**Applicant:** Begbroke Oxford Limited

**Proposal:** Several design changes to the services building (proposed as non-material amendment to 21/03195/F)

DATE: 4 May 2023

DRAWING NAME:
PROPOSED FLOOR & ROOF PLAN - SERVICES BUILDING

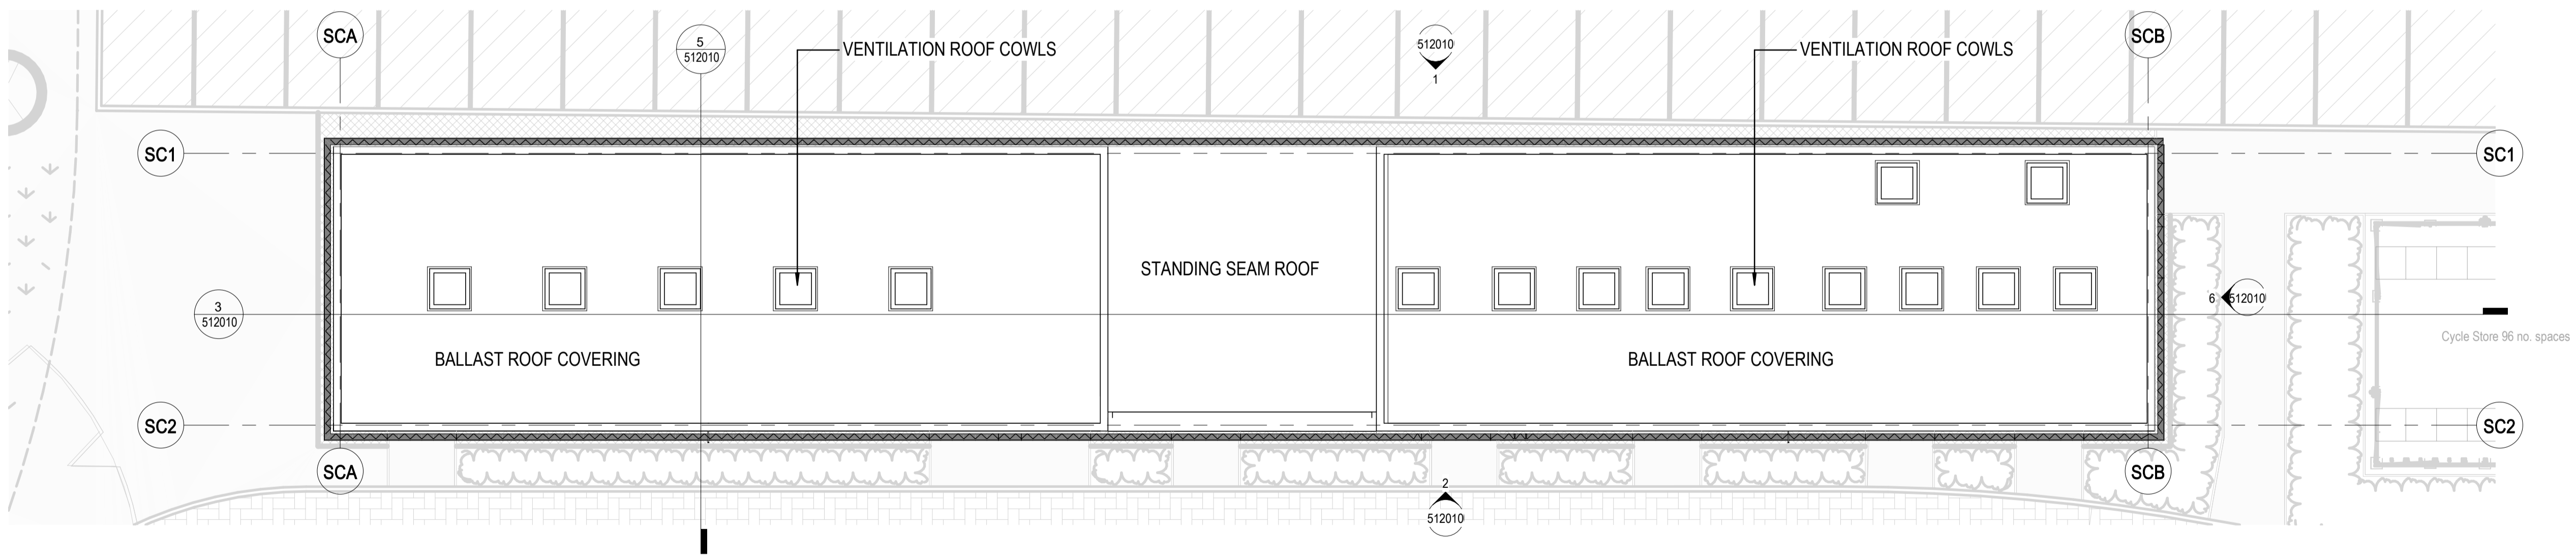
- 5.4. The proposed changes to the roof, i.e. the installation of the ventilation and the surface treatment are considered minor in relation to the visual interpretation of the building and would not be seen except from distance or higher vantage points within surrounding buildings.

DRAWING NAME:
PROPOSED ELEVATIONS & SECTIONS - SERVICES BUILDING

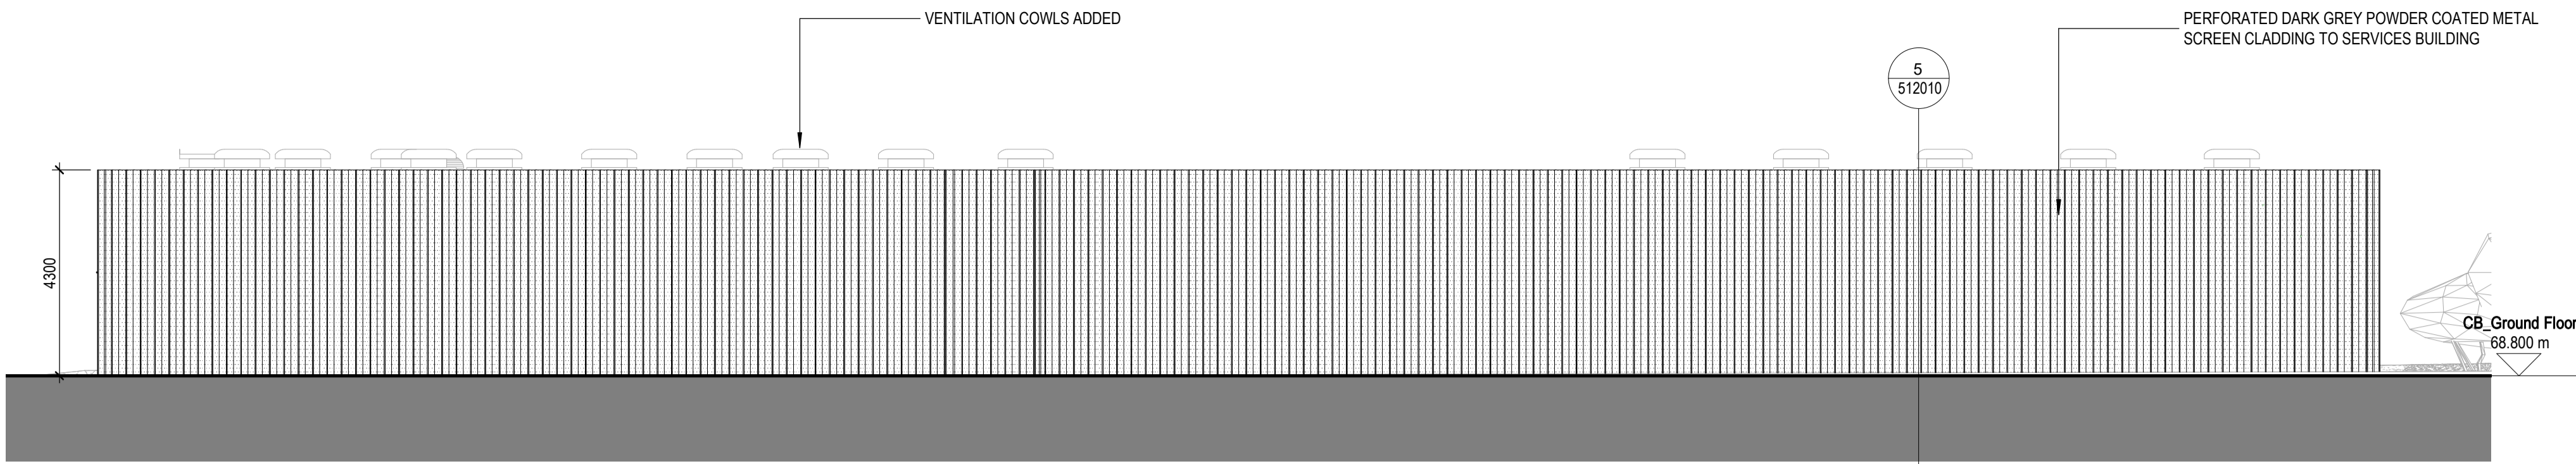
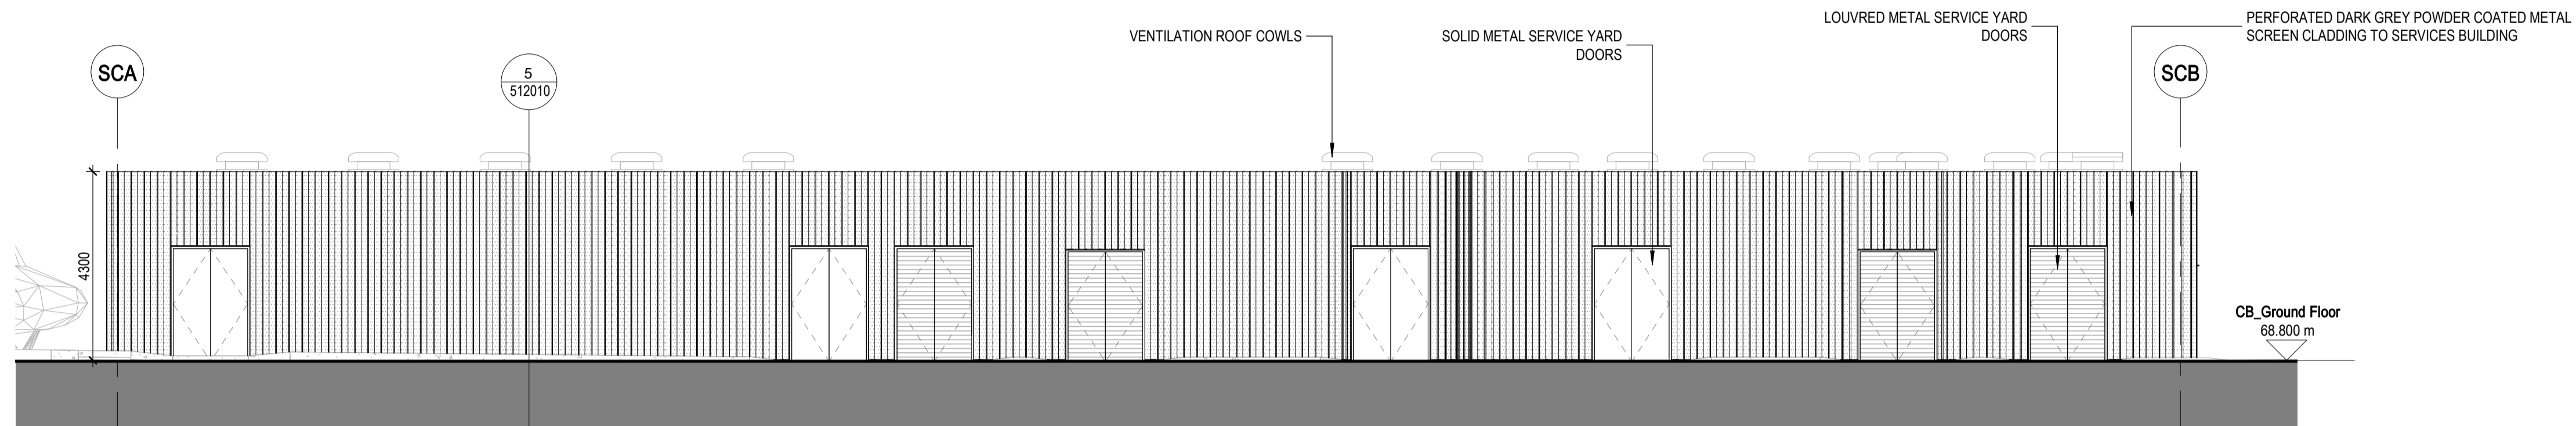
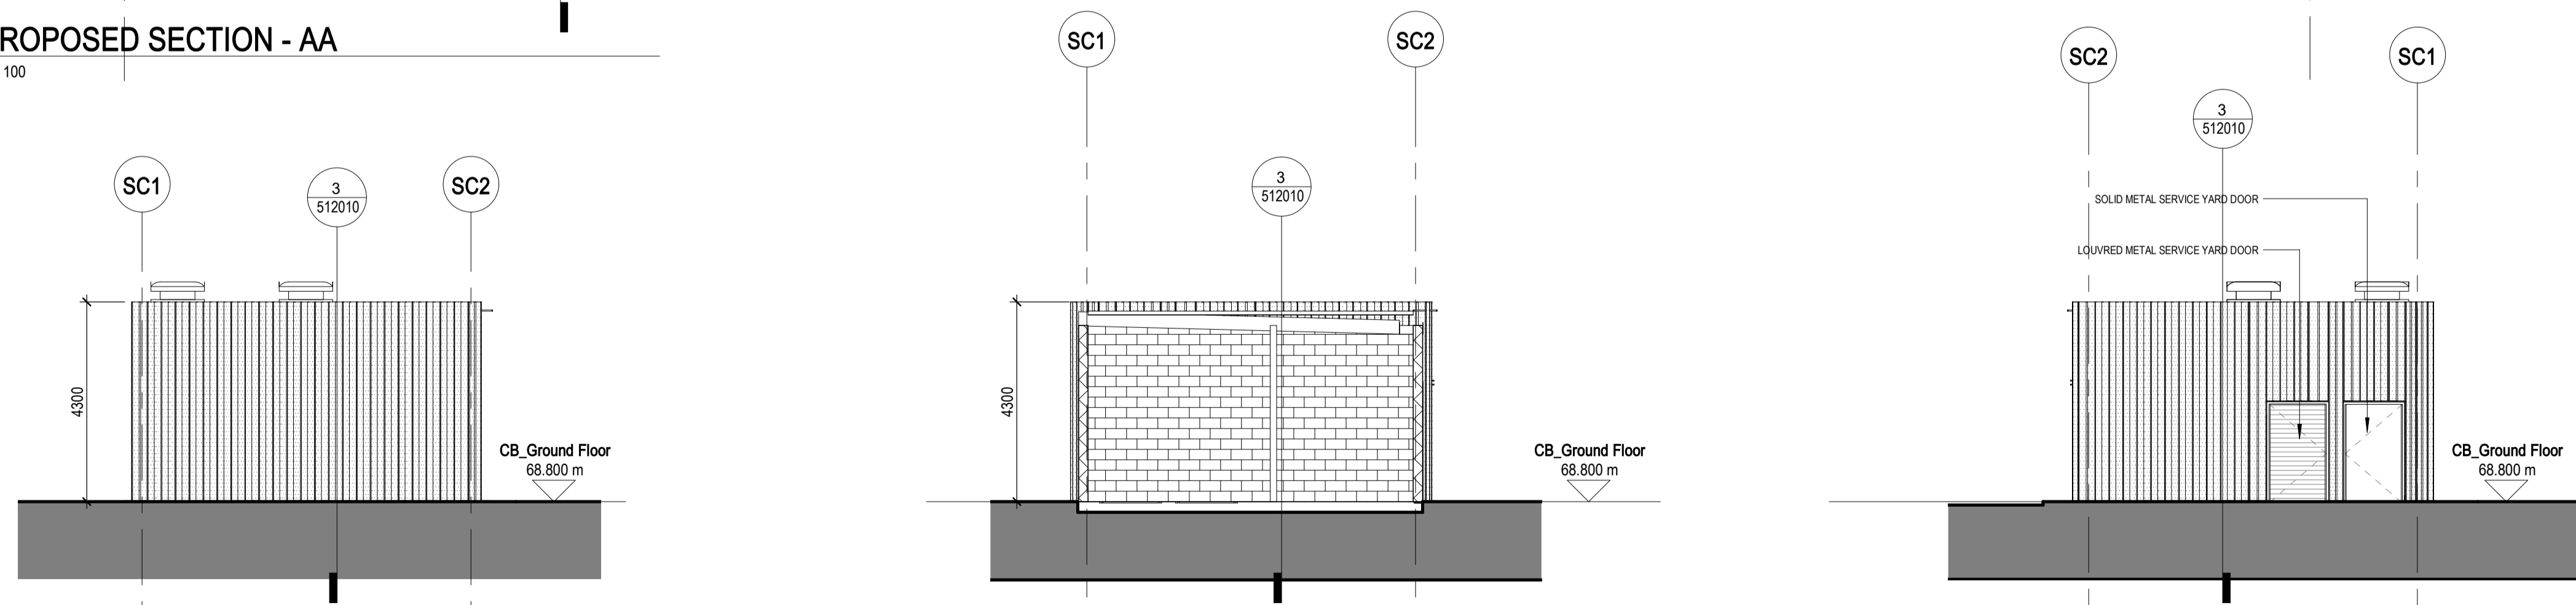
- 5.5. The changes to the south elevation and the position and size of the doors are also noted. The doors are now less uniform in nature but this reduces the functional feel of the design which could be considered a positive feature of the changes and the additional door to the east elevation would not add a significant change to the character of the building. The reduction in the height of the building would also not be readily interpreted.

- 5.6. Overall, individually and cumulatively the proposed changes would not significantly alter the building and would be considered as non-material.
